The Secretary  
NSW Planning, Industry & Environment

23 June 2021

I refer to the Department's below email of 17 June 2021 regarding the public exhibition of the Environmental Impact Statement (EIS) for State Significant Development SSD-10224 New Primary School at Edmondson Park for 'New primary school including 1000 primary school students and a pre-school' at Buchan Avenue, Edmondson Park (Lots 1 and 2 DP 1257105) in the Liverpool City Local Government Area. Submissions need to be made to the Department by 14 July 2021.

Figure 2.3 – Proposed new Kiosk substation and new MSB location

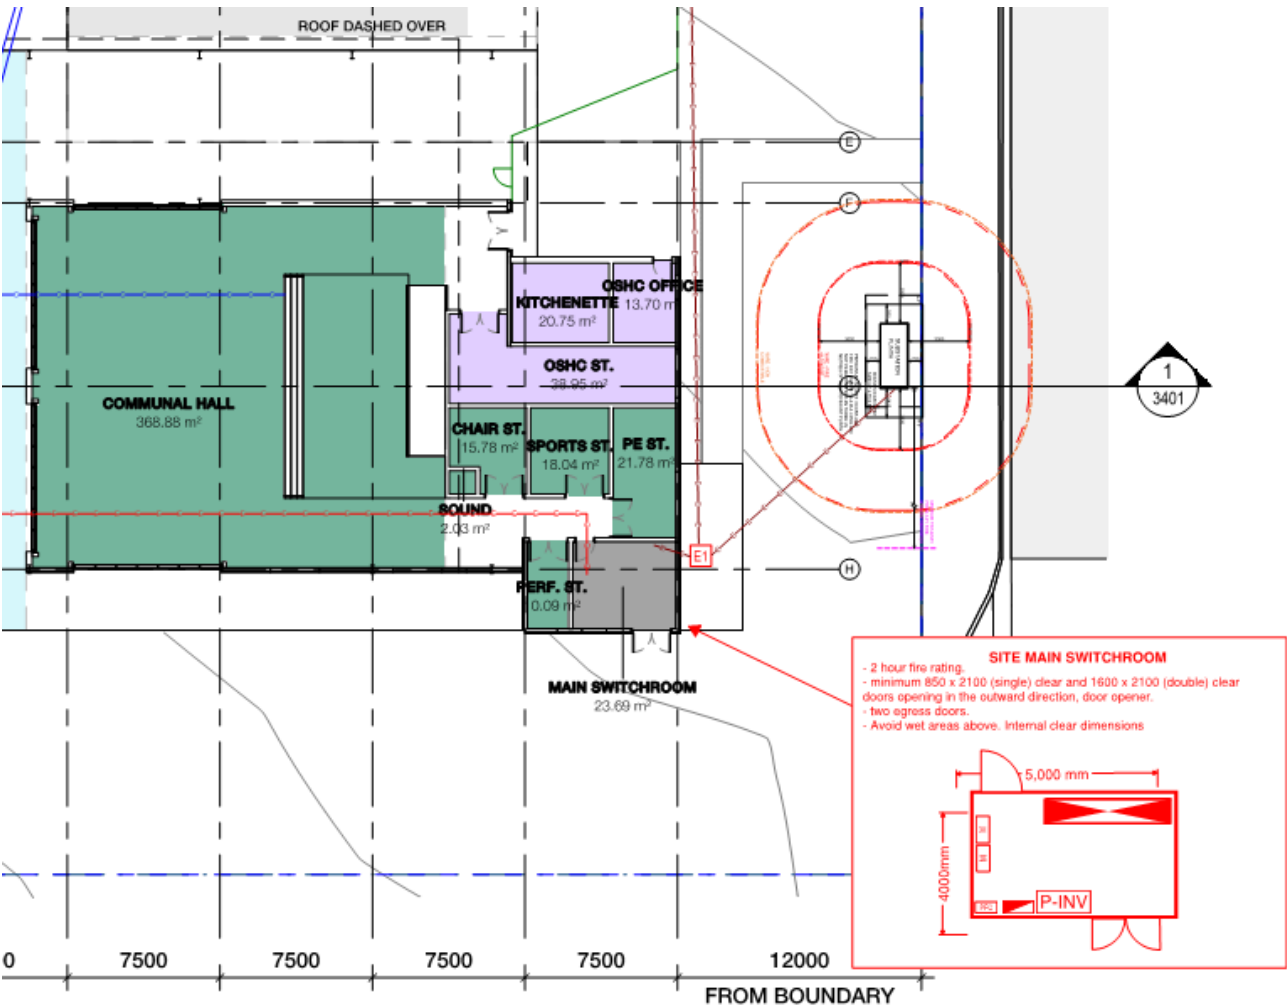
Based on the requirements above, JHA have proposed the following location for the new KL kiosk substation which is located on the Buchan Avenue street frontage as per Figure 2.3.

From Endeavour Energy's perspective the fact that provision is being made for a padmount substation is a positive. Endeavour Energy's general requirements is for a padmount substation to be at ground level and have direct access from a public street (unless provided with appropriate easements for the associated underground cables and right of access).

As shown in the following extract of Endeavour Energy's Mains Design Instruction MDI 0044 'Easements and Property Tenure Rights', Figure A4.3 'Padmount easements and clearances', padmount substations require:

- Easement with a minimum size of 2.75 x 5.5 metres (single transformer).
- Restriction for fire rating which usually extends 3 metres horizontally from the base of the substation footing / plinth and 6 metres vertically from the same point.
- Restriction for swimming pools which extends 5 metres from the easement.

Generally it is the Level 3 Accredited Service Provider's (ASP) responsibility (engaged by the developer) to make sure that the substation location and design complies with Endeavour Energy's standards the suitability of access, safety clearances, fire ratings, flooding etc. As a condition of the Development Application consent the Department should request the submission of documentary evidence from Endeavour Energy confirming that satisfactory arrangements have been made for the connection of electricity and the design requirements for the substation, prior to the release of the Construction Certificate / commencement of works.

Drawing No. **AR- W-DW- 2001** Revision **E**

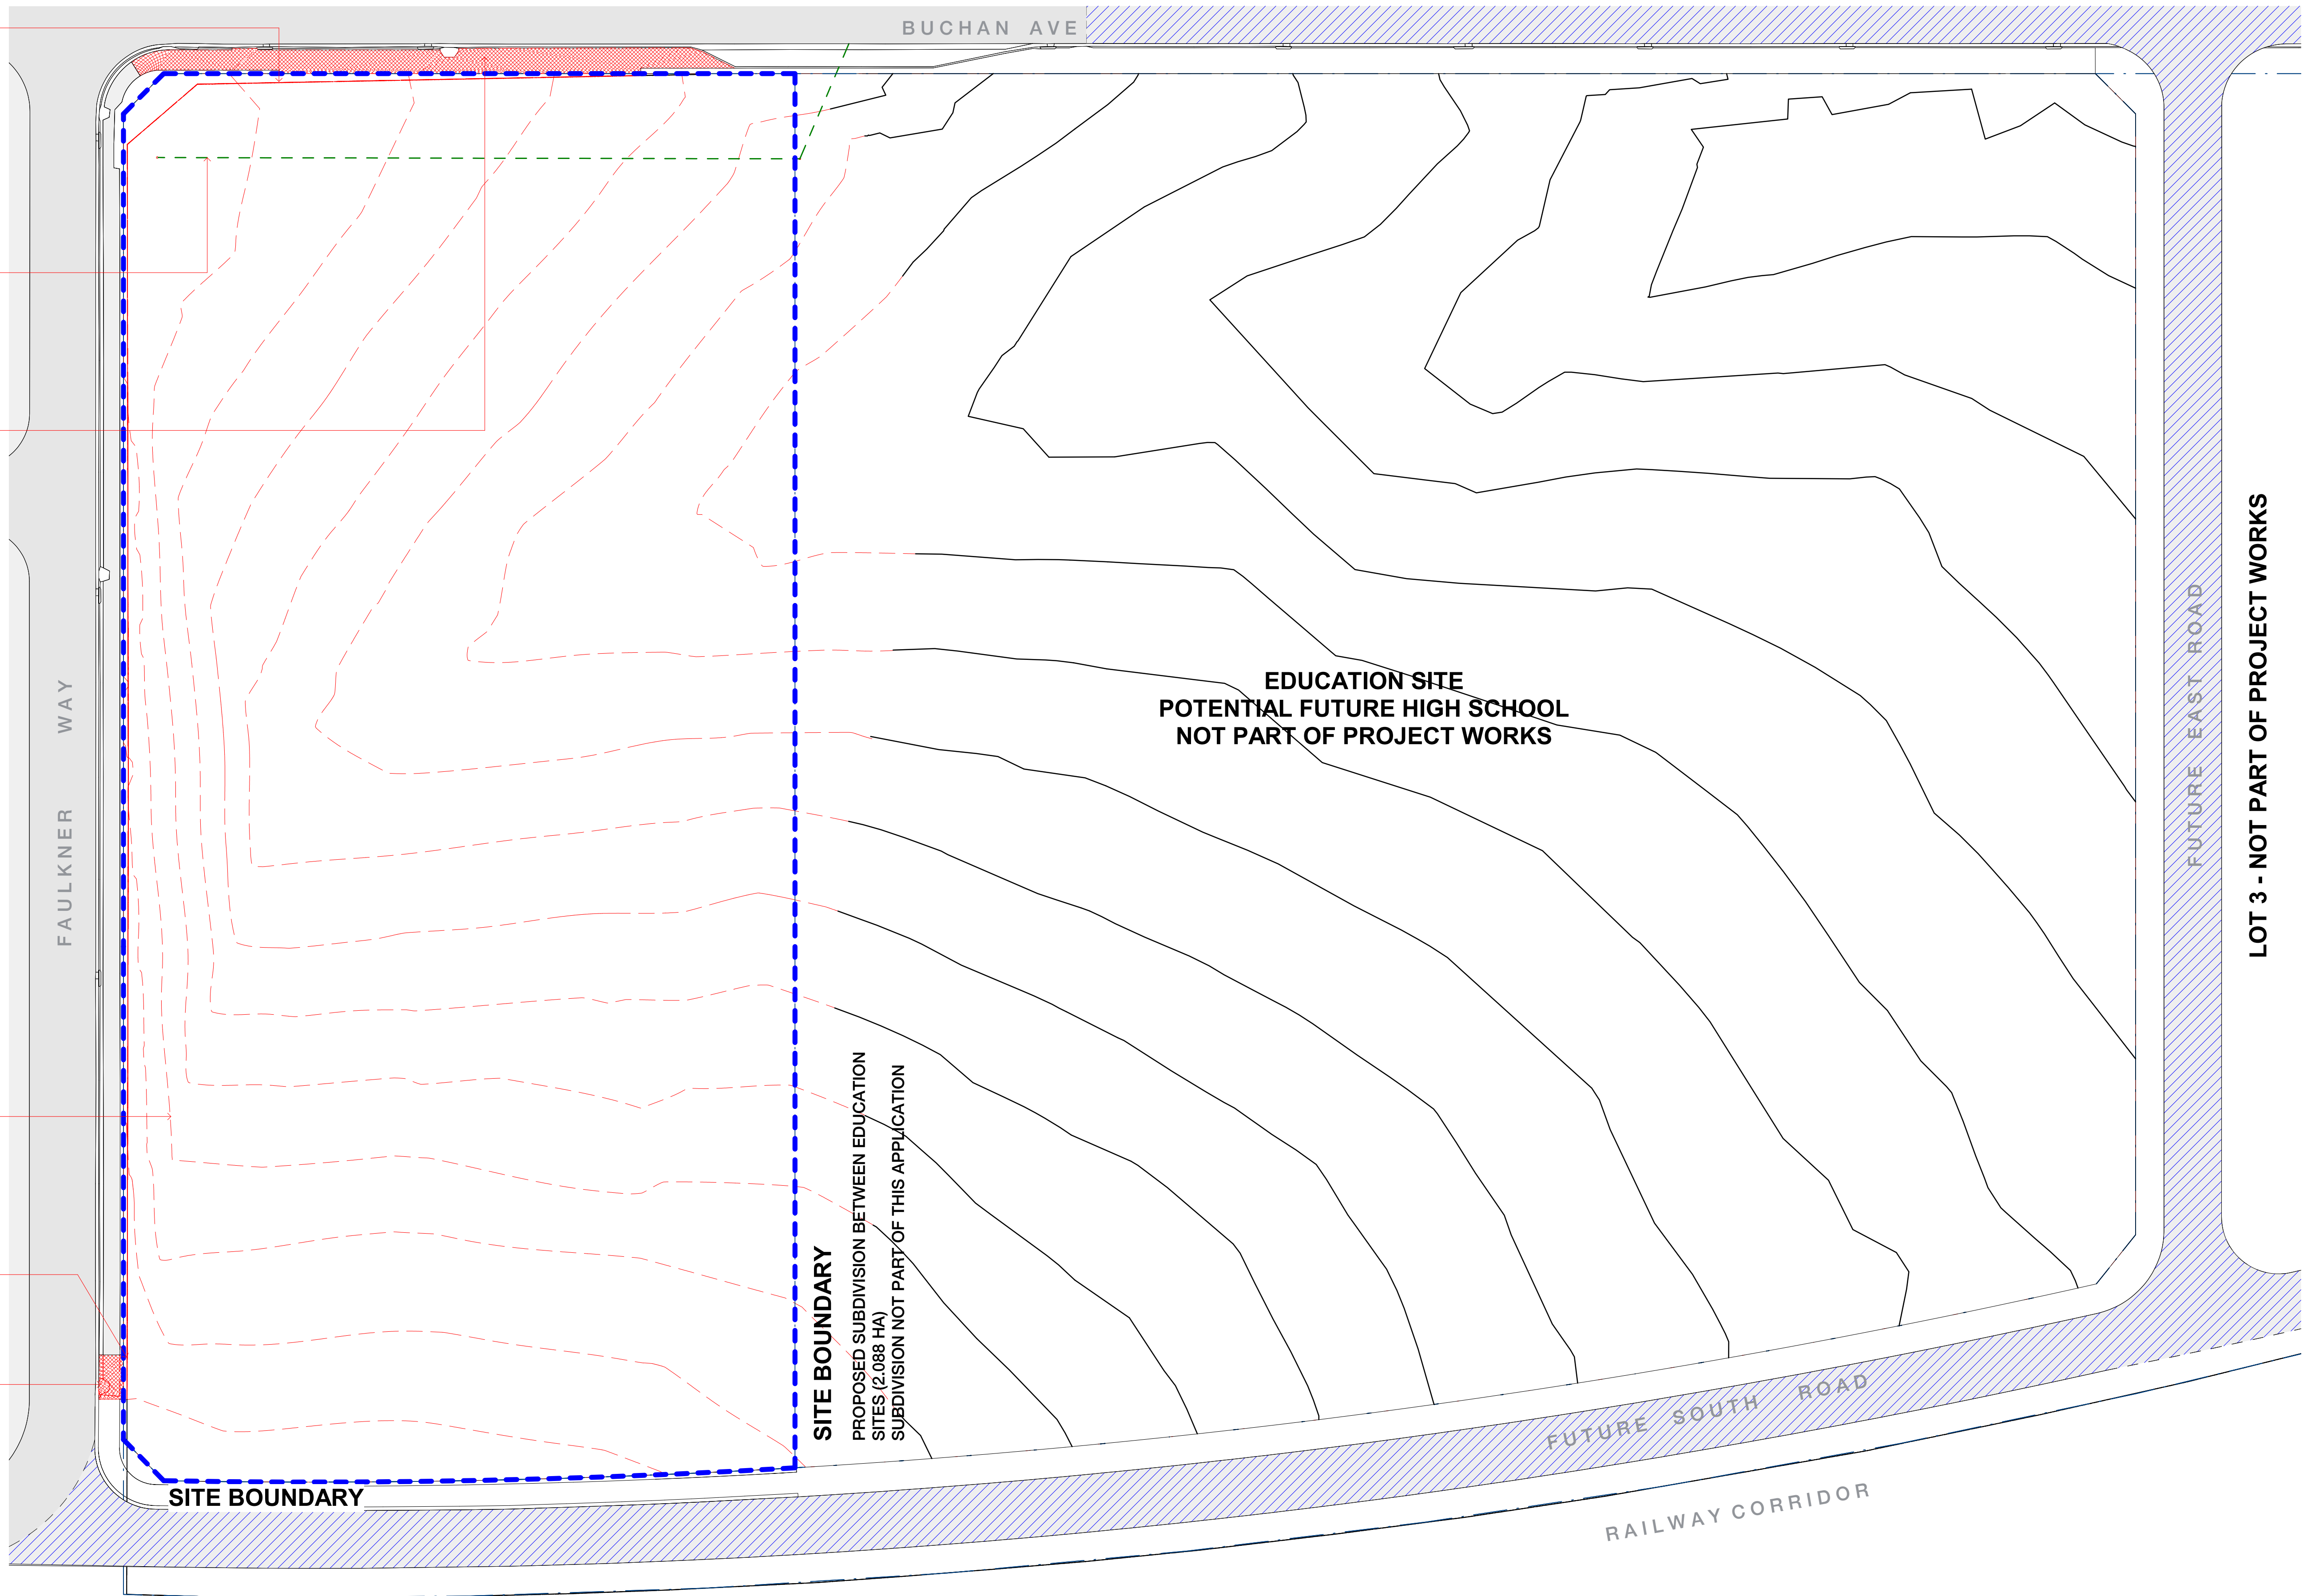
In regard to the easement over the site for overhead power lines, as shown in the following extract of the Architectural Design Report dated June 2021 '(E) overhead power lines and associated power poles on Survey have been demolished prior to this development'.

(E) OVERHEAD POWER LINES AND ASSOCIATED POWER POLES ON SURVEY HAVE BEEN DEMOLISHED PRIOR TO THIS DEVELOPMENT

*About a month ago Landcom approached Endeavour to sign a NSW Land Registry Services (LRS) dealing to release the easement. This has occurred and the dealing has been returned to Landcom to lodge with LRS.*

The overhead power lines within the easement have been removed and arrangements for the release of easement are in place.
